YorkshireWater

Your Ref: 2017/91214
Our Ref: T006479

Heaton Avenue First and Nursery School , Westcliffe Road, Cleckheaton - Reserved matters application pursuant to outline permission 2014/91791 for demolition of existing school building and erection of residential development (18 dwellings)

Drawing
**PROPOSED DRAINAGE
STRATEGY**

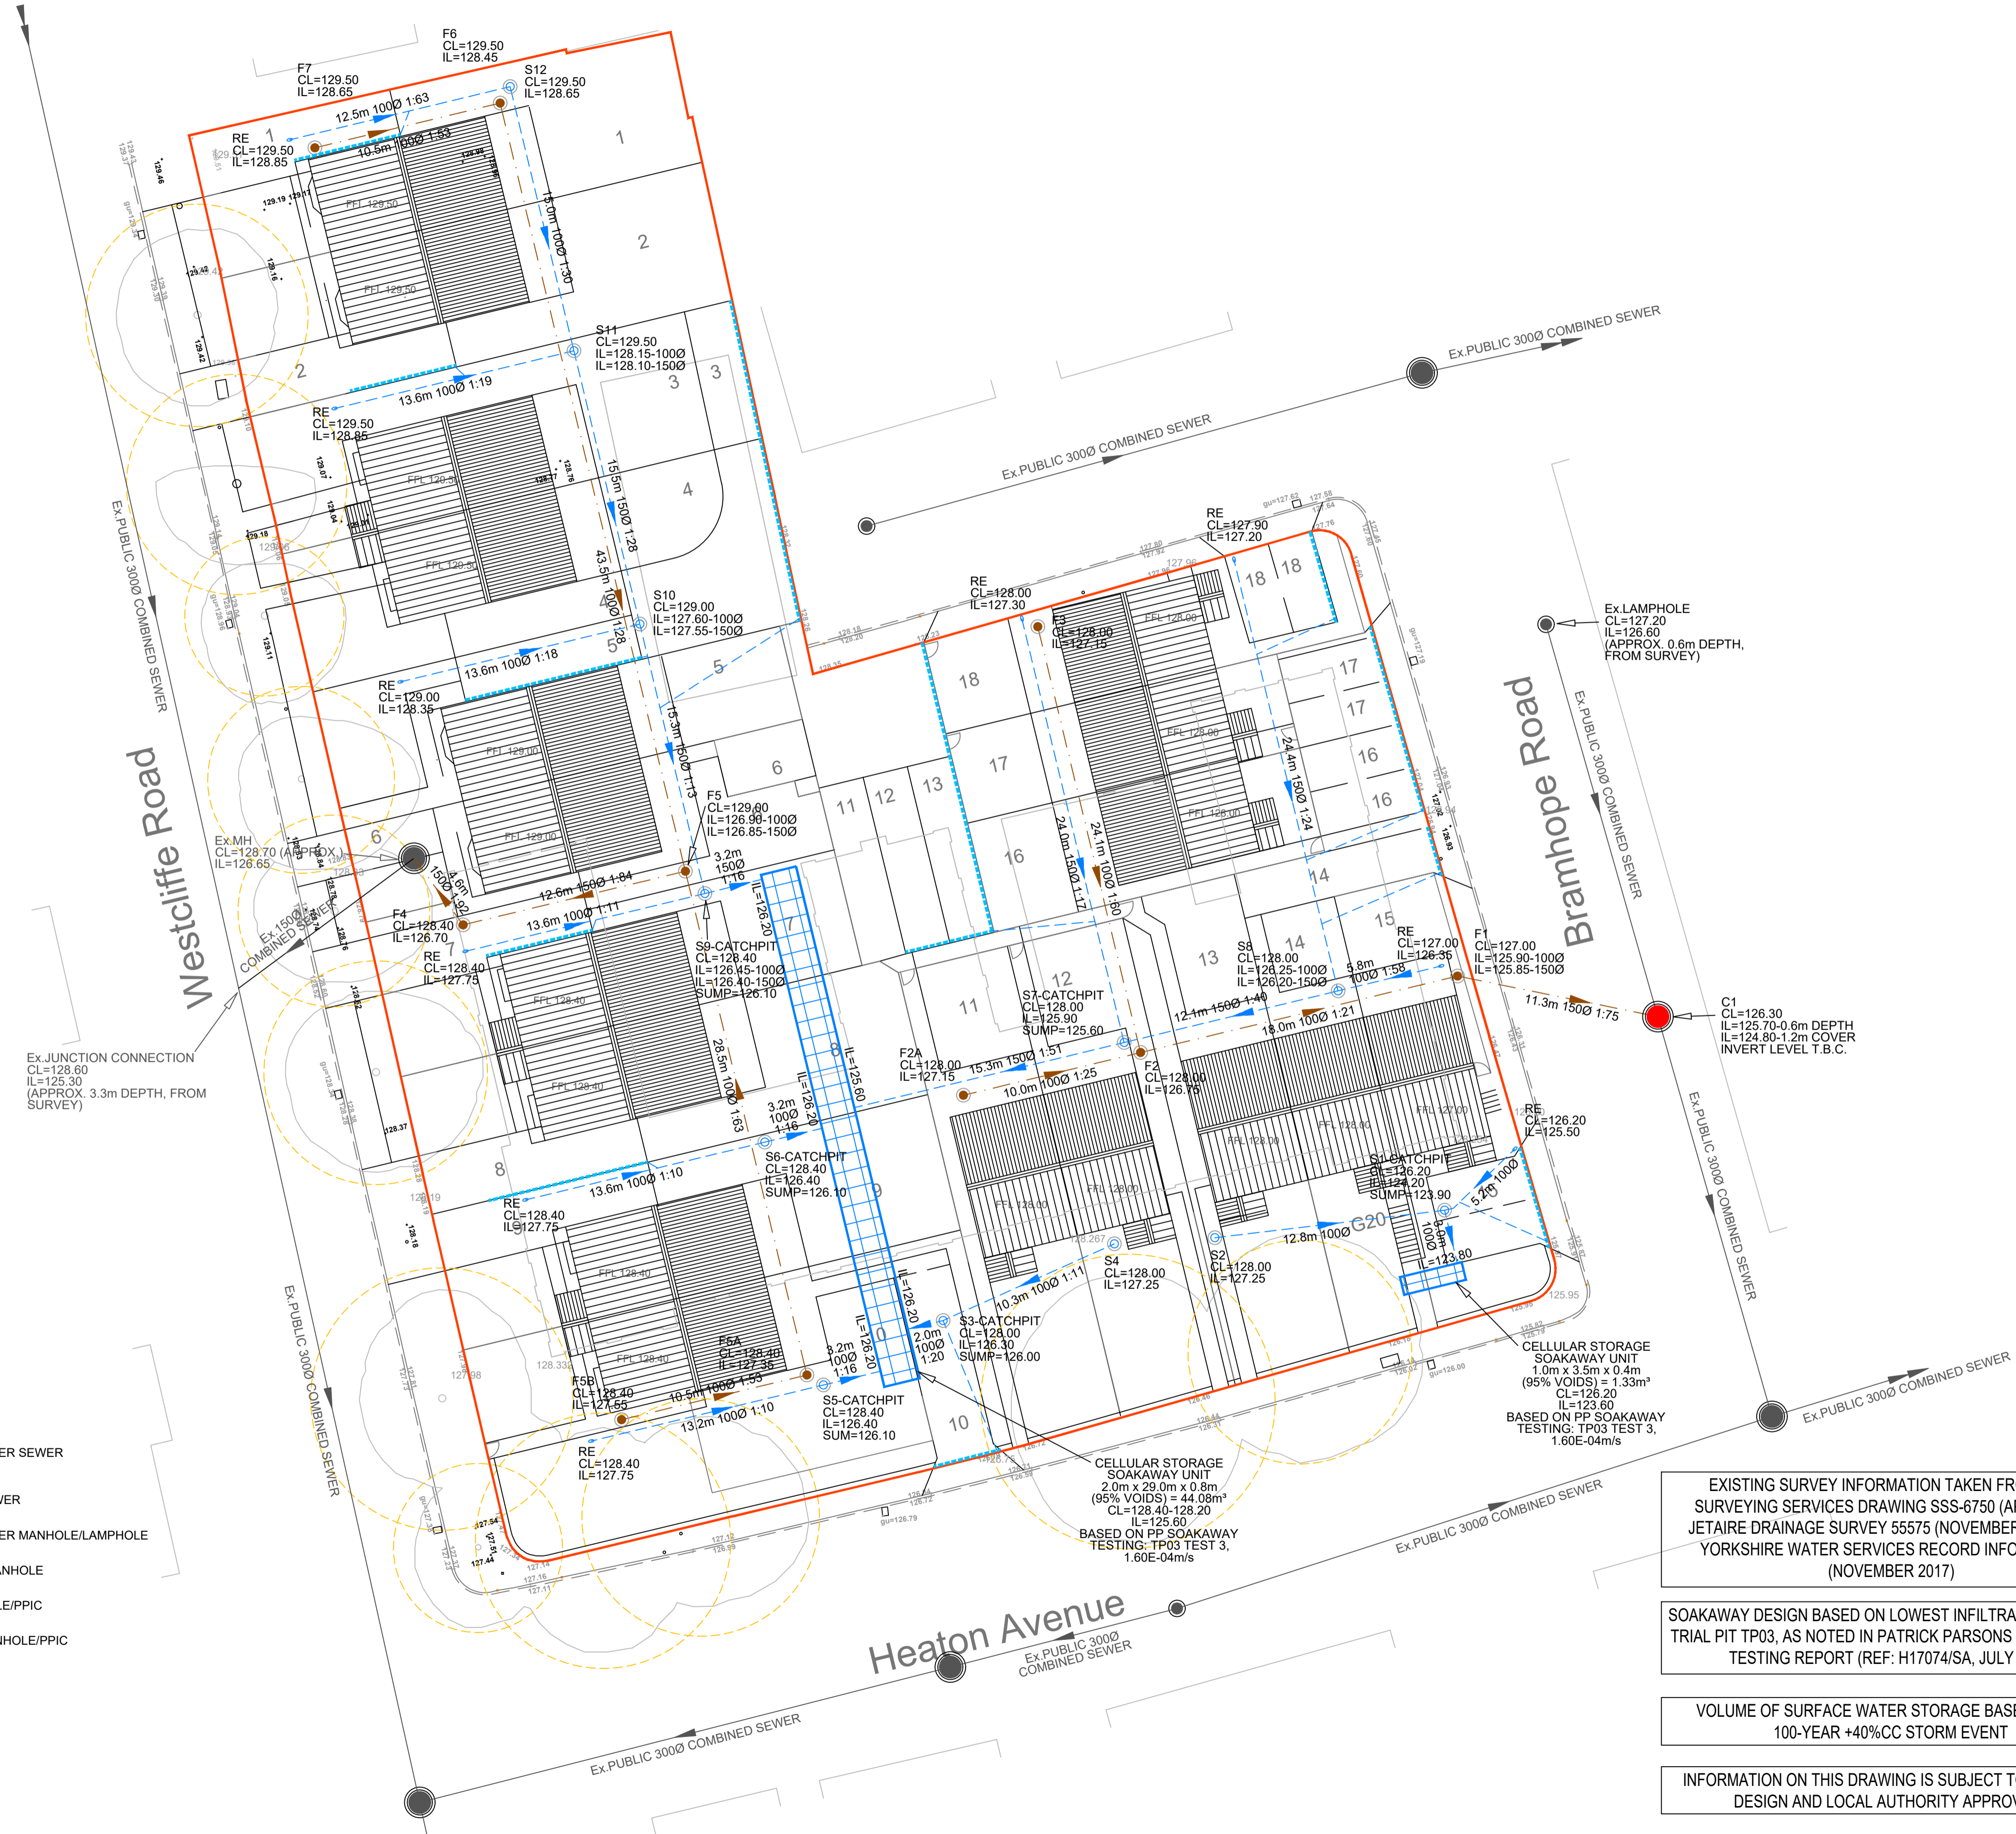
The submitted Proposed Drainage Strategy H17074-210 revision P1, prepared by Patrick Parsons, dated 14.12.17 is acceptable, as the drawing indicates that surface water will discharge to soakaway.
